## **St Catherine's School Master Plan (SSD 6339)**

**Independent Traffic & Transport Review**

**October 2015**

TRAFFIC MANAGEMENT AND PARKING

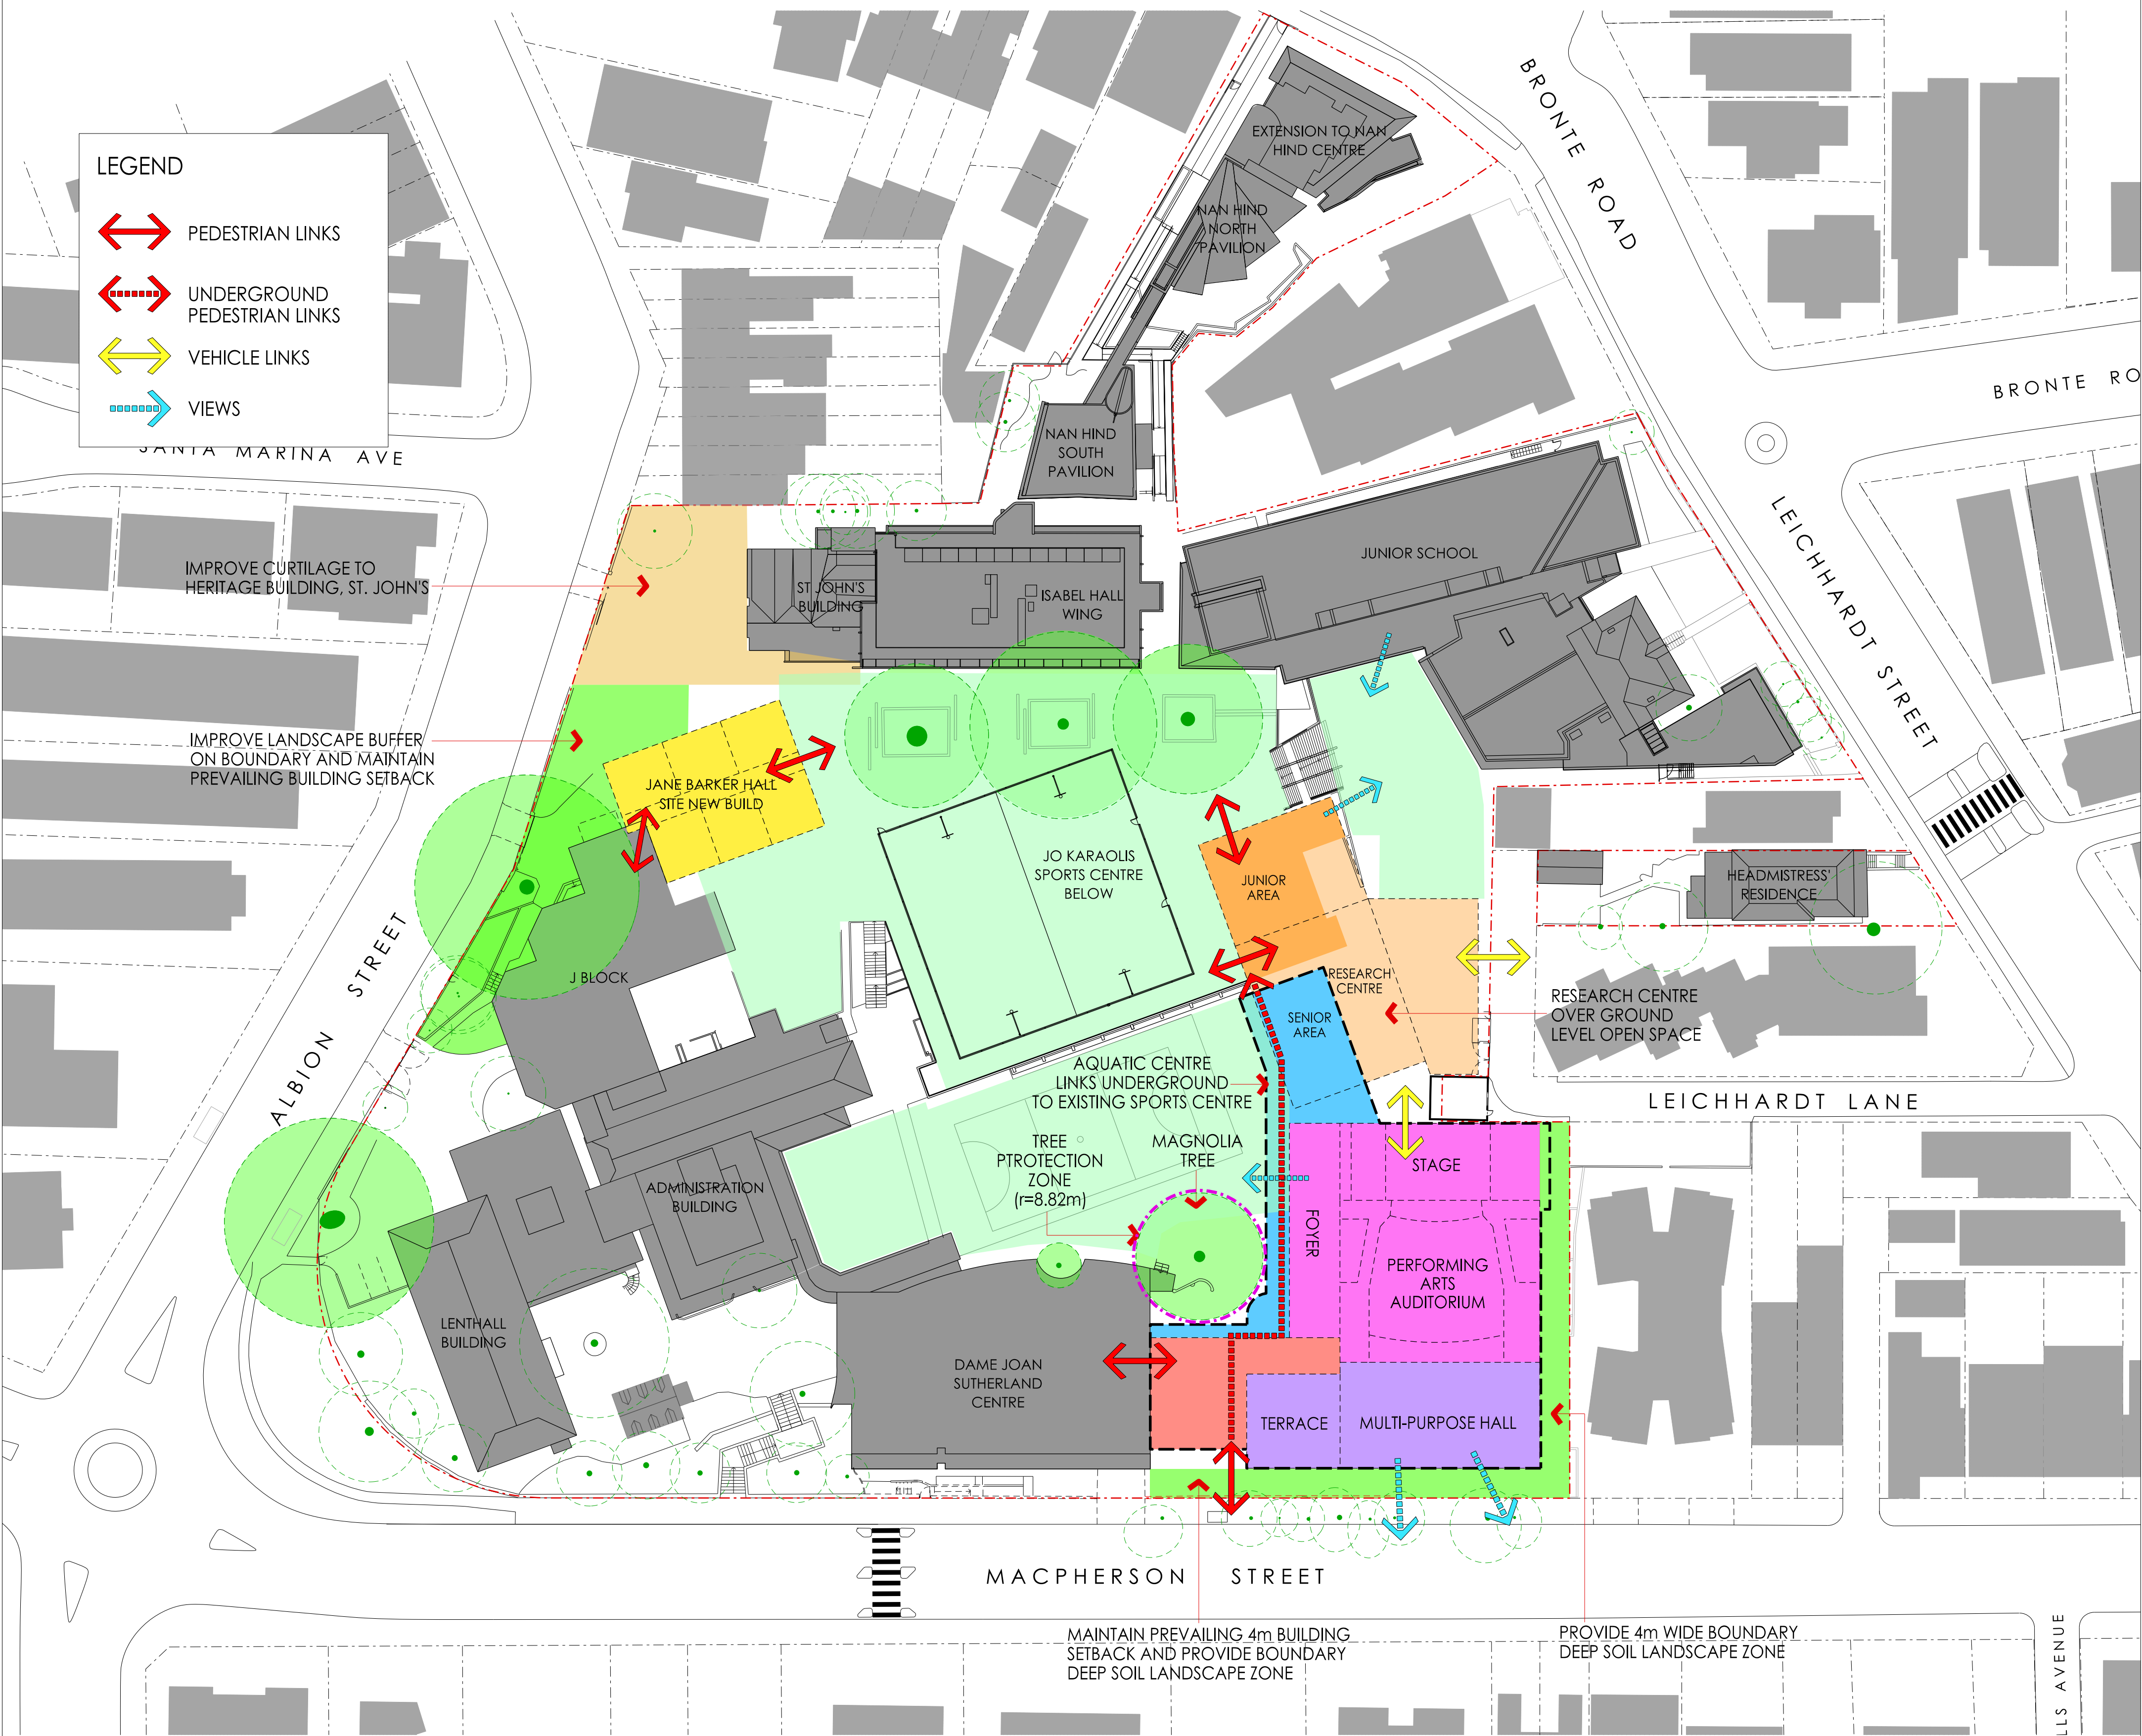
- There is an existing potential road safety issue for the car park exit onto Macpherson Street with sight distance being restricted to the east by street trees. This has not been mentioned / acknowledged by the assessment and would be exacerbated by an increase in parking spaces to be accessed via the same car park driveway. The NSW Police submission has suggested that the car park access should become left-in / left-out to prevent obstructing following vehicles when turning right into the car park off Macpherson Street and right-turning exiting vehicles from 'forcing' their way into the westbound traffic stream. This measure could potentially operate well because of the roundabouts at either end of Macpherson Street, which would allow cars to access the car park from the west and exit to the east. However, this measure may require some form of physical traffic control to enforce the left-turn only movements.

*A restricted left-in / left-out movement restriction for the car park access may be considered, but a central median would not be supported as this may open possibilities for unsafe pedestrian storage in the centre of the road as well as considerably impacting road width.*

[Noted, however, there is no specific commitment and timeframe for when this measure would be determined and implemented.]
